Planning Consultation Request
Town and Country Planning Act 1990
APPLICATION FOR PERMISSION TO DEVELOP LAND

Application No.	2025/90578
Proposed Development:	Change of use and internal alterations of first, second and third floors to form 5 apartments (Listed Building within a Conservation Area)
Location:	Prudential House, 69, New Street, Huddersfield, HD1 2BQ
OS Map Reference	SE 414441.5748 416469.8781
Applicant/Agent:	Northern Design Partnership
Class:	Minor Developments
Site Area (sq. m):	180.0

**Consultation Response from KC,
Conservation & Design**

**Change of use and internal alterations of first, second and third floors to form 5 apartments
(Listed Building within a Conservation Area)**

client	HD CENTRAL		
project	CHANGE OF USE OF UPPER FLOORS INTO APARTMENTS 69-71 NEW STREET HUDDERSFIELD HD1 2BQ		
drawing	PROPOSED PLAN LAYOUTS		
revision	notes	date	drawn
A	NOTES ADDED FOLLOWING SITE MEETING WITH LPA.	05.25	PB
scale :	1:50 AT A1	02.25	MG
project no.	drawing no.	revision	
2388	03	A

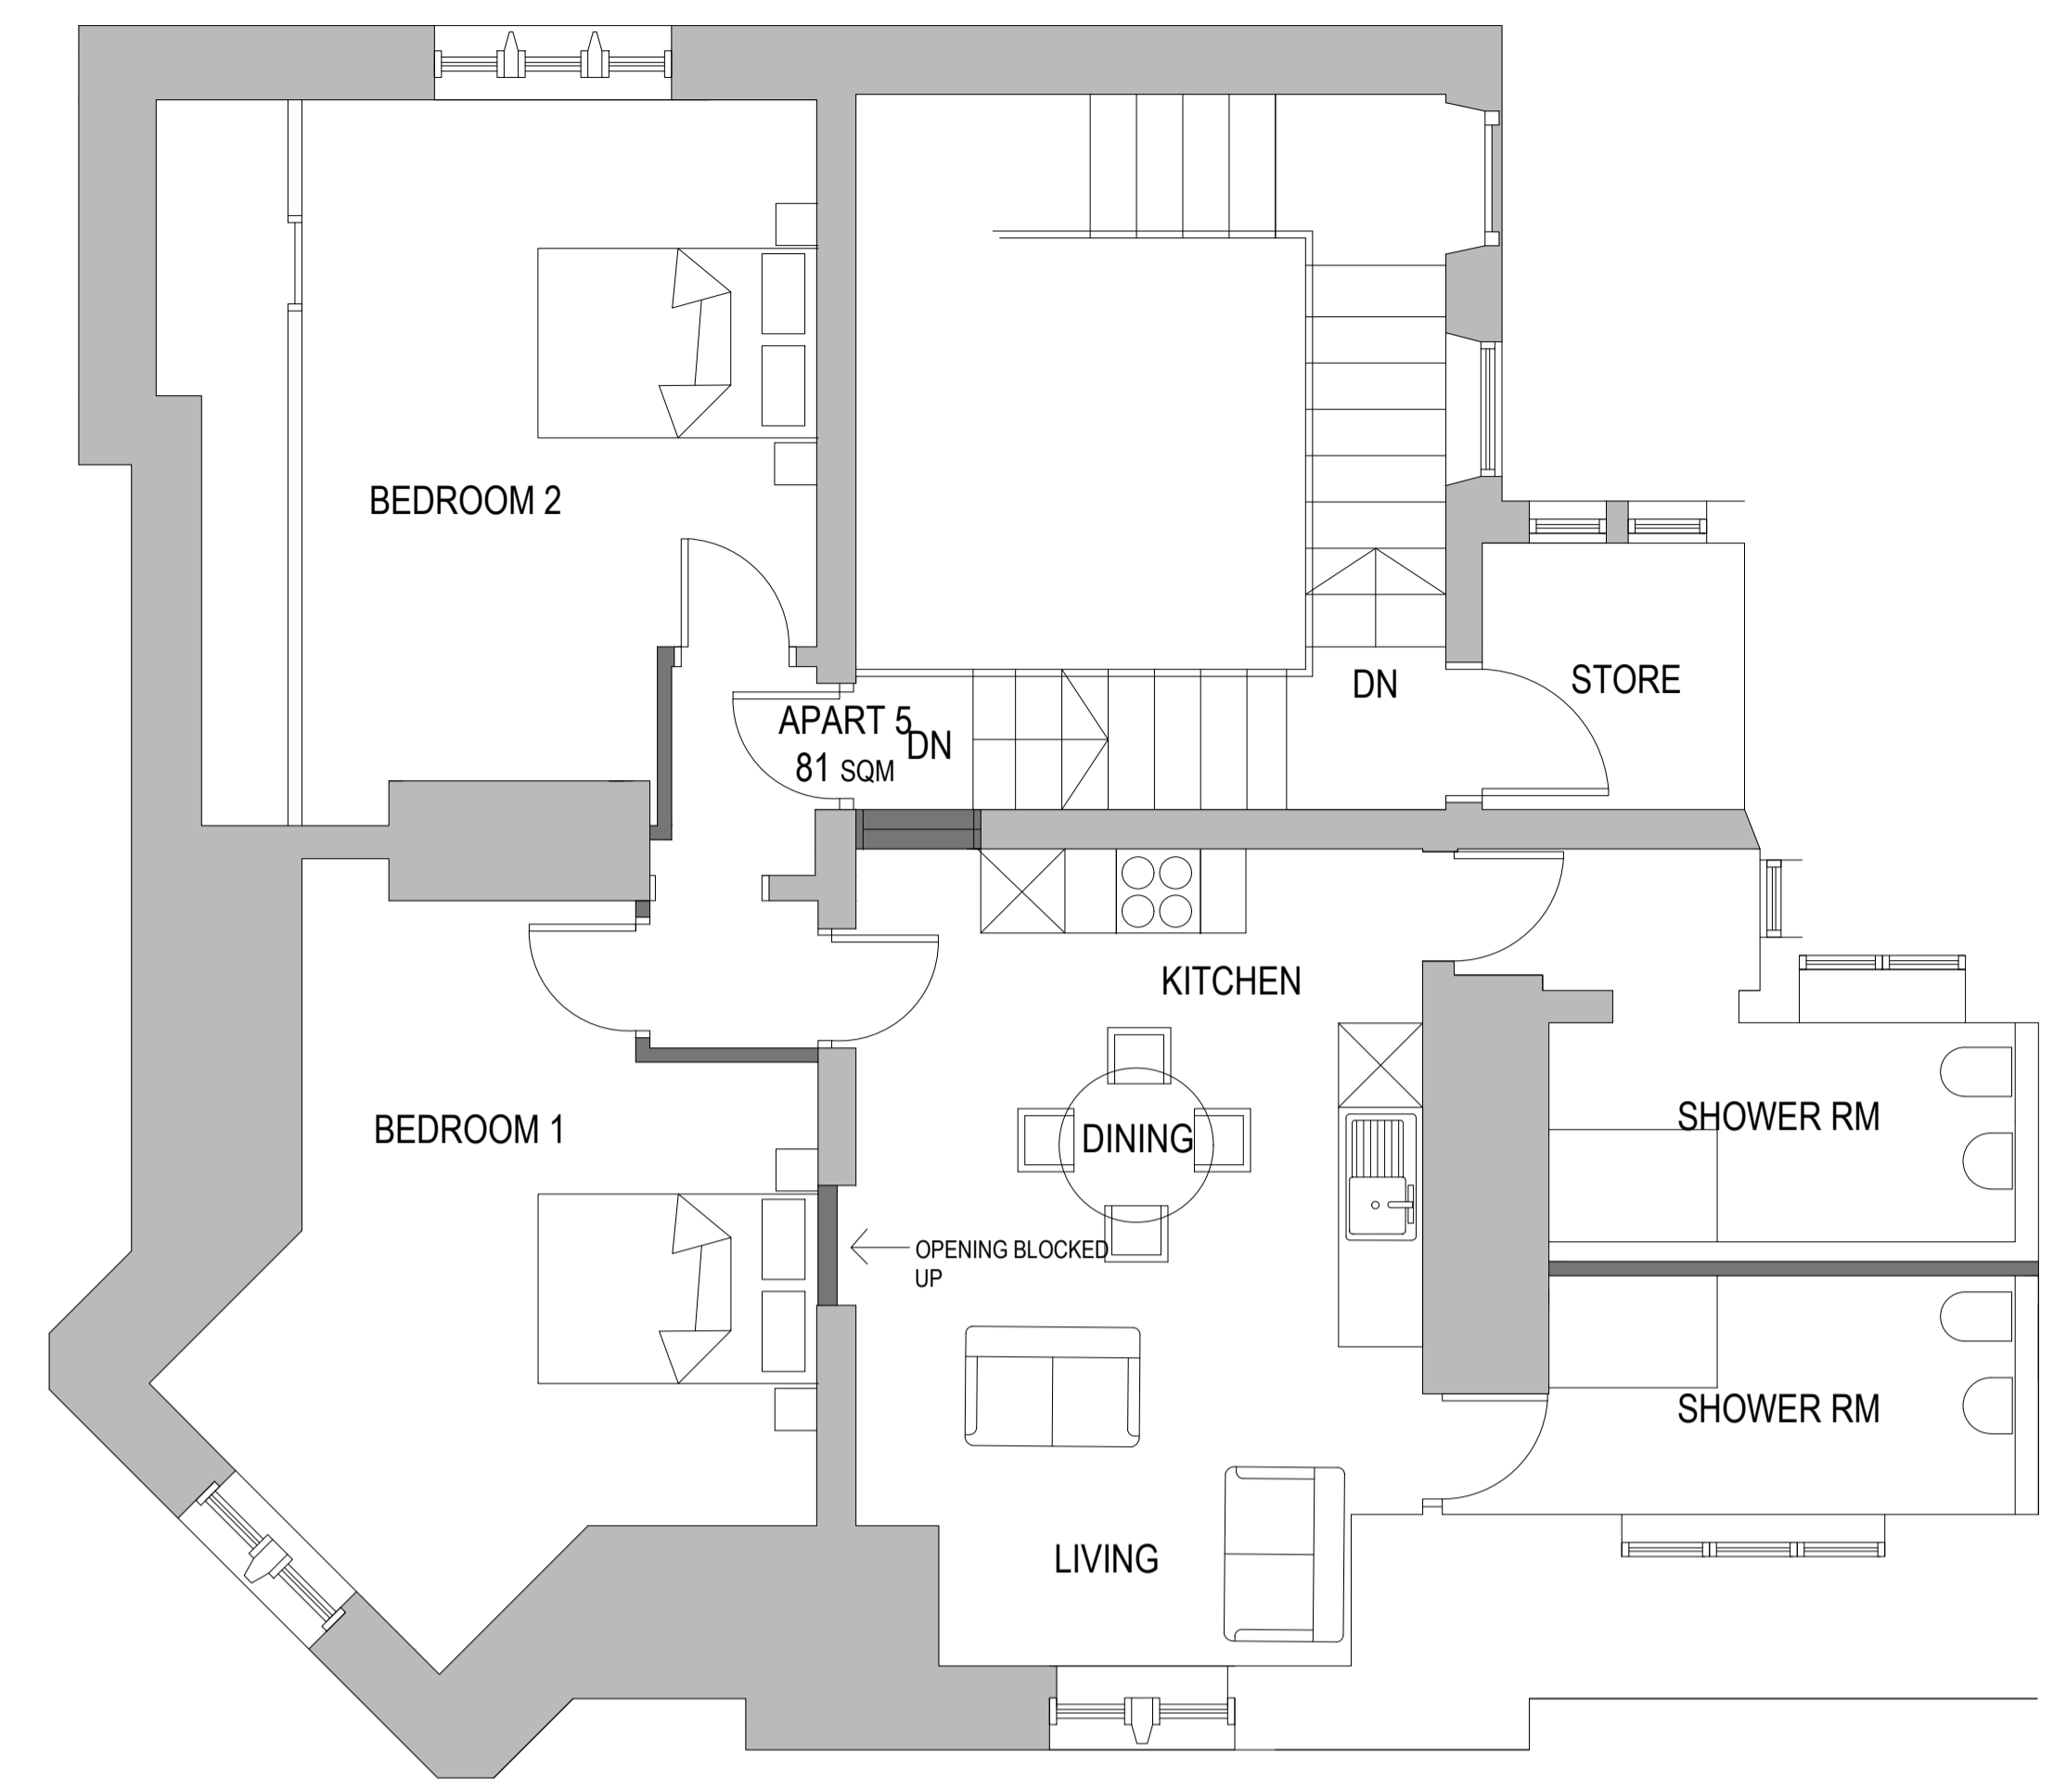
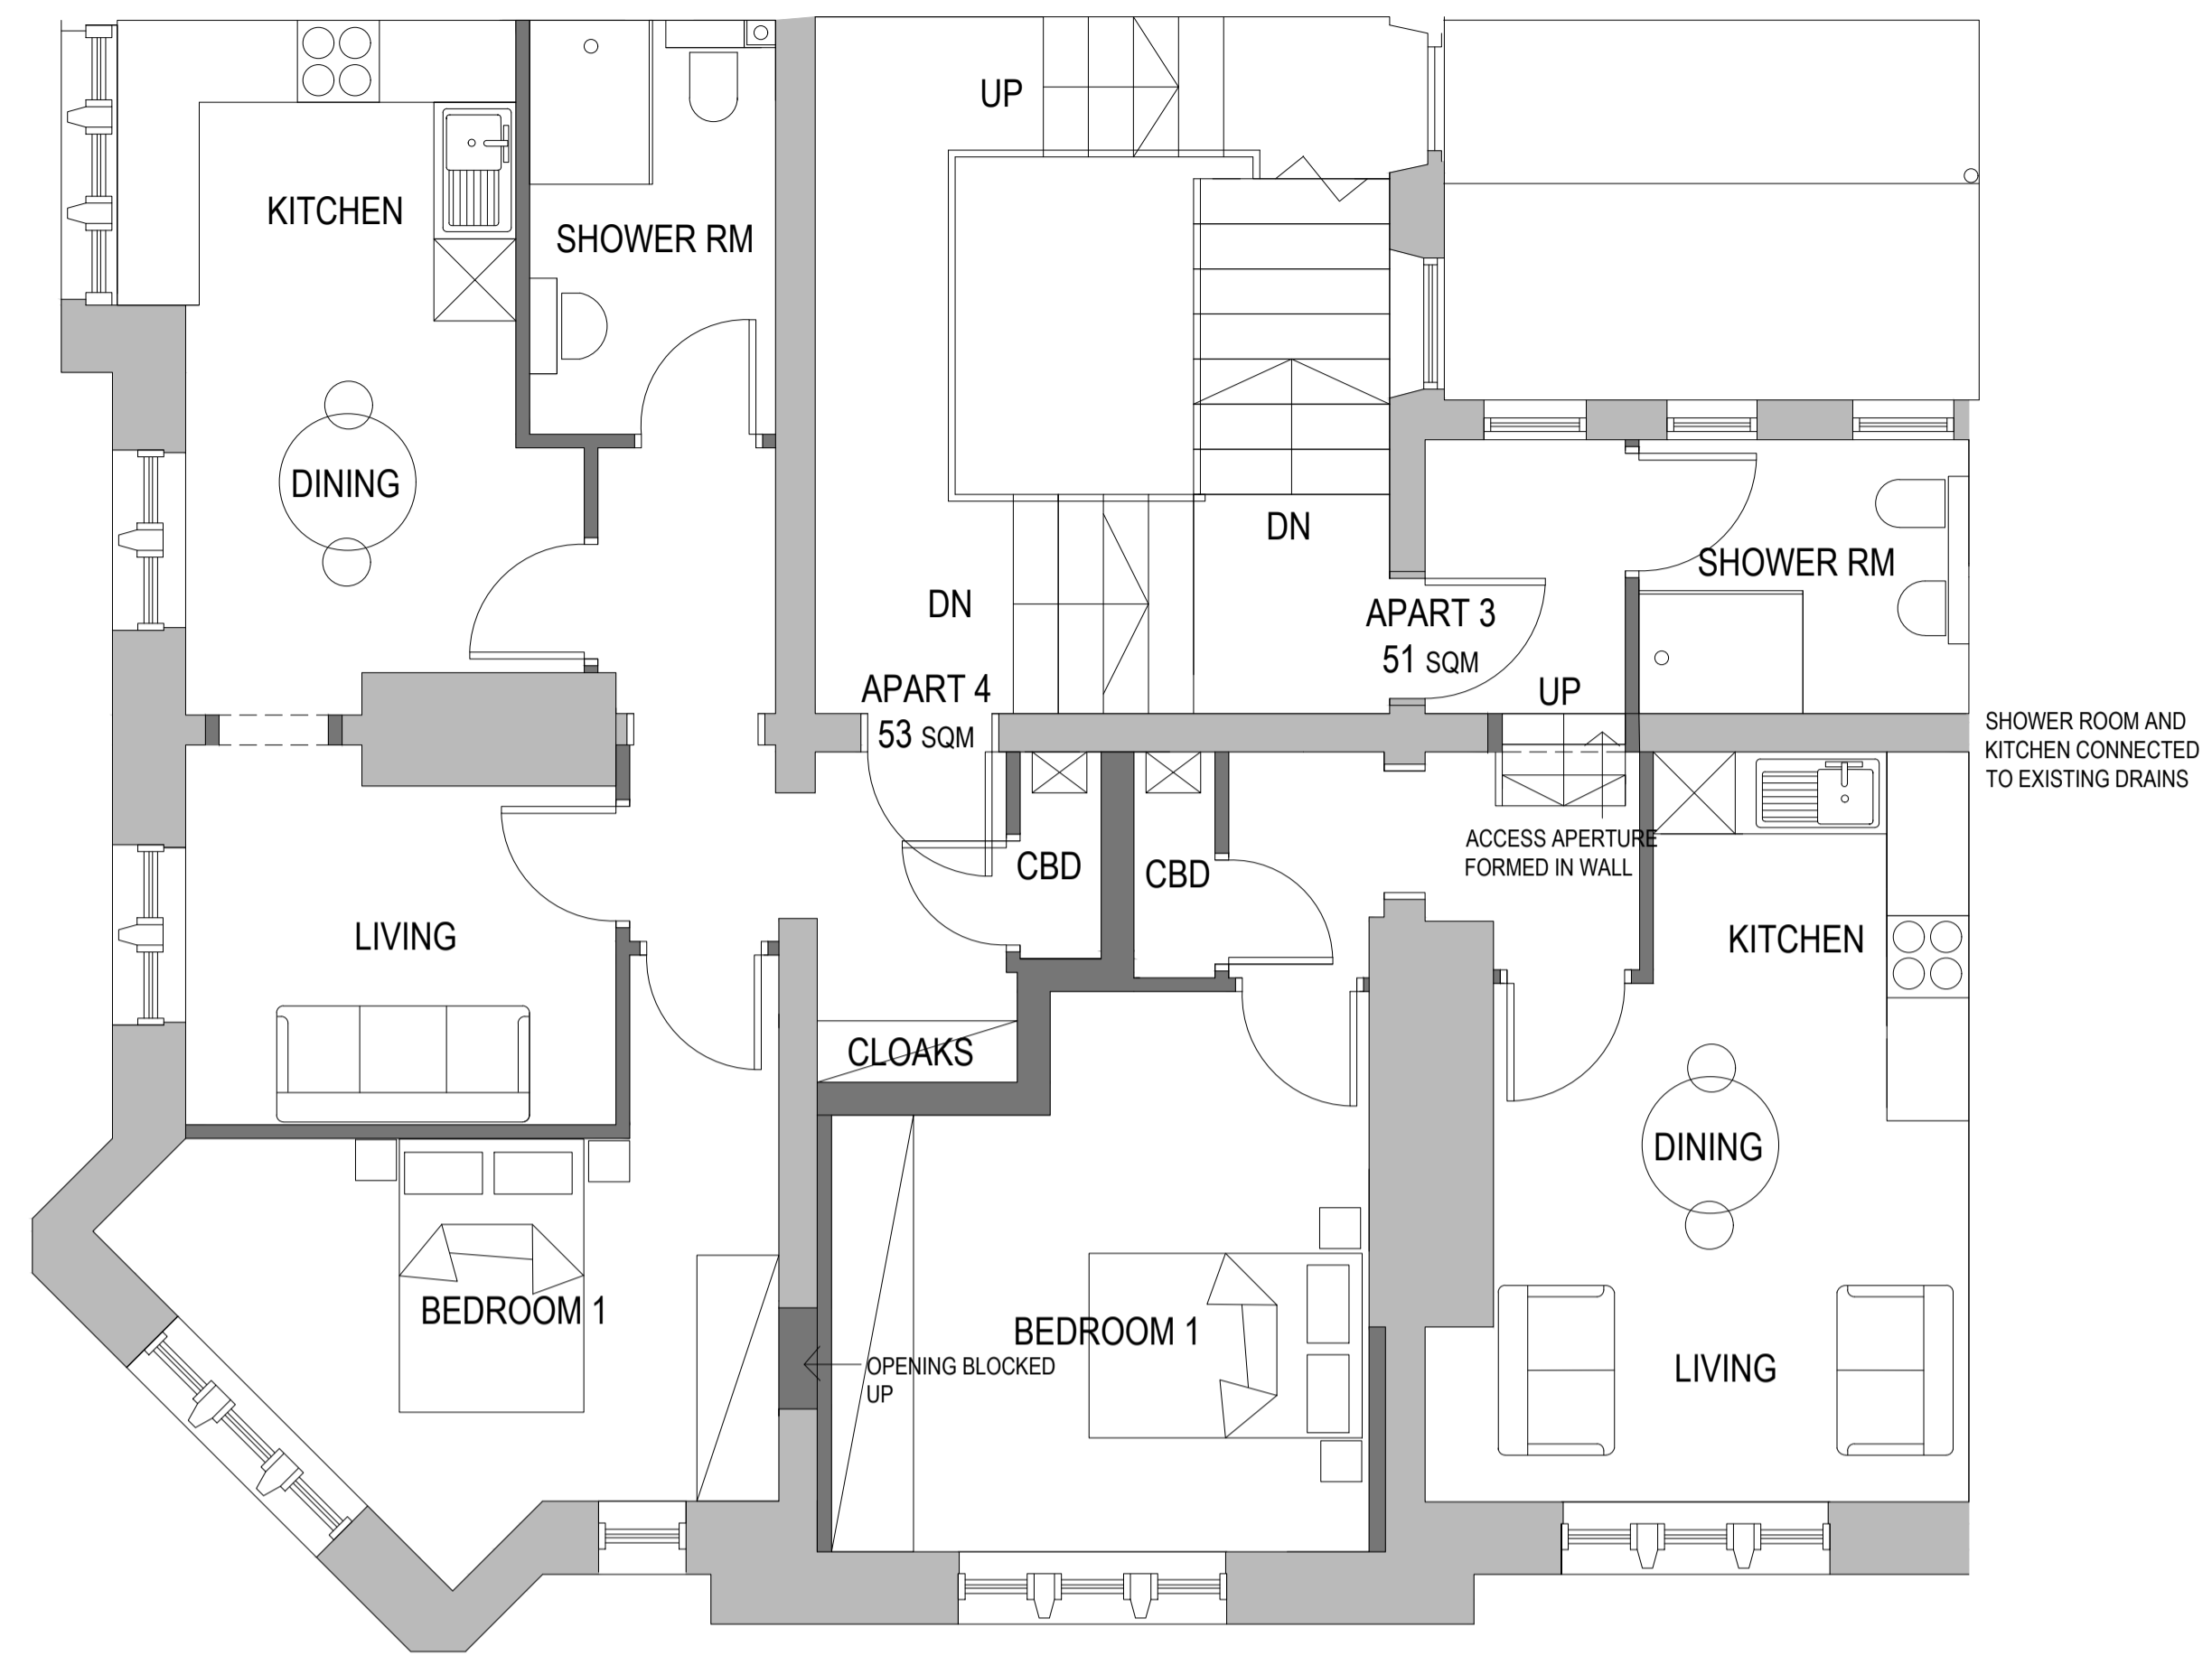
As discussed on site, the agent has agreed to add extra annotation to the plans to indicate the following;

1. The 2 fireplaces on the top floor will be retained and reinstated.
2. The mosaic entrance flooring and wooden parquet flooring within flats will be retained (under new floor coverings where necessary).
3. Ceiling decoration including cornices and picture rails will be retained, any new suspended ceilings will be set below the cornices to avoid any damage.
4. Original internal panelled doors will be retained where possible inside flats.
5. Original windows and external doors will be retained (but secondary glazing is acceptable).
6. Window surrounds and panelling below windows shall be retained.
7. Original deep skirting boards shall be retained.

8. The staircase and balustrading shall be retained. Any amendments that may be required to satisfy Building Regulations shall be submitted in writing with detailed drawings showing the handrail and any extra restraint requirements.

The proposed plans should be amended and annotated to indicate that the features set out above will be preserved and retained.
